Office of
Environment
& Heritage

Our Ref. DOC16/524271

Springvale Water Treatment Project (SSD 7592)

Springvale Water Treatment Project Recommendations

Figure 5: Vegetation and Threatened Species

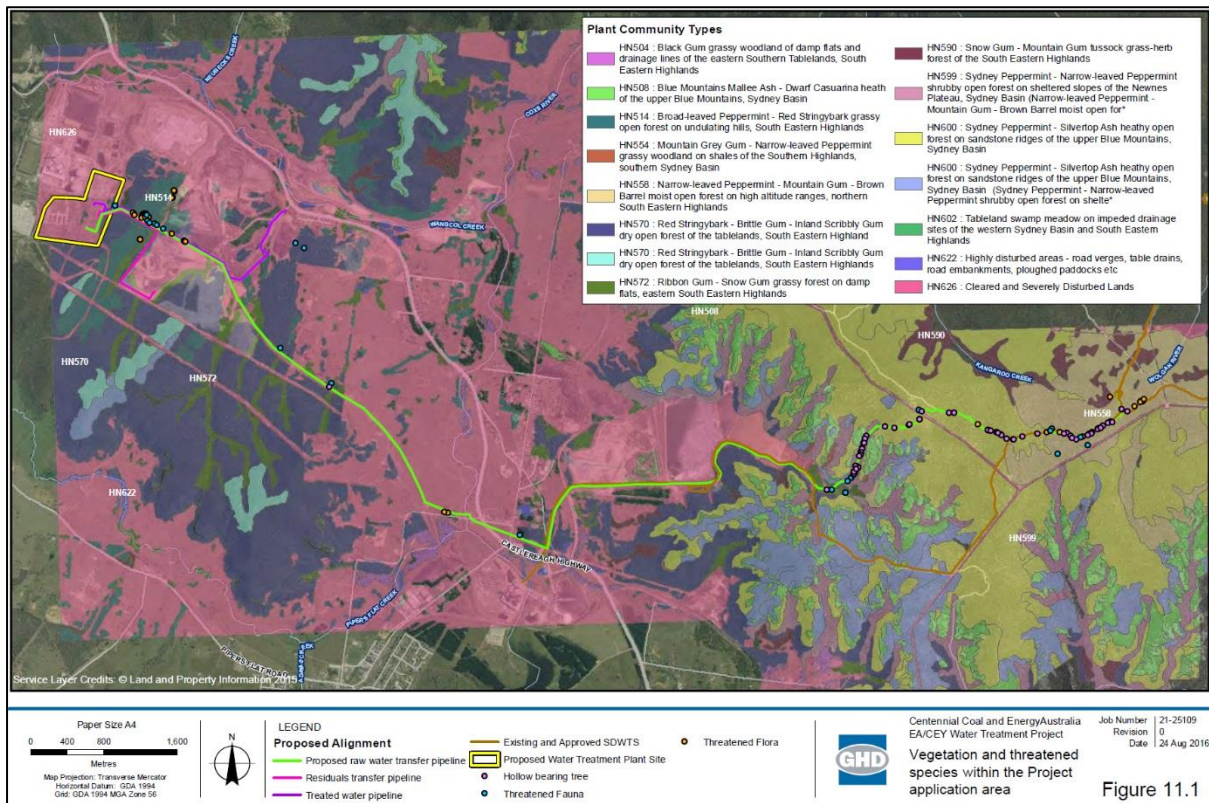
Section 4.2, Impact Minimisation, provides further detail of potential opportunities to avoid some impacts on individual threatened plants and hollow trees. This includes the potential to completely avoid impacts to *Persoonia hindii* as well as avoiding three individuals of *Caesia parviflora* var. *minor* and three individuals of *Eucalyptus cannonii*. The BAR does, however state that these assumptions would be confirmed prior to construction through the completion of pre-construction surveys to validate offsetting requirements. Recommendations regarding *C. parviflora* var. *minor* are made below.

Three individuals of this cryptic species were identified (despite flora surveys being conducted outside its flowering season) as being potentially impacted. All known records within the Study Area are within the Sydney Basin Wollemi IBRA subregion. The BAR recommends that pre-construction surveys be conducted within the Southern Study Area during the flowering period. As the BAR recommends the Northern Study area as the preferred route for the pipeline the rationale for the surveys in the Southern Study Area is unclear. OEH recommends pre-construction surveys be conducted in all areas of suitable habitat to determine the size and extent of the local population and determine the number of individuals that may potentially be impacted.

7. All efforts should be made to avoid impacts to *Caesia parviflora* var. *minor*.
8. Pre-construction surveys for *C. parviflora* var. *minor* be conducted in all areas of suitable habitat to determine the size and extent of the local population and determine the number of individuals that may potentially be impacted.
9. The definition of local population should be redefined to reflect the potential contact of *C. parviflora* var. *minor* within the Study Area with other populations.
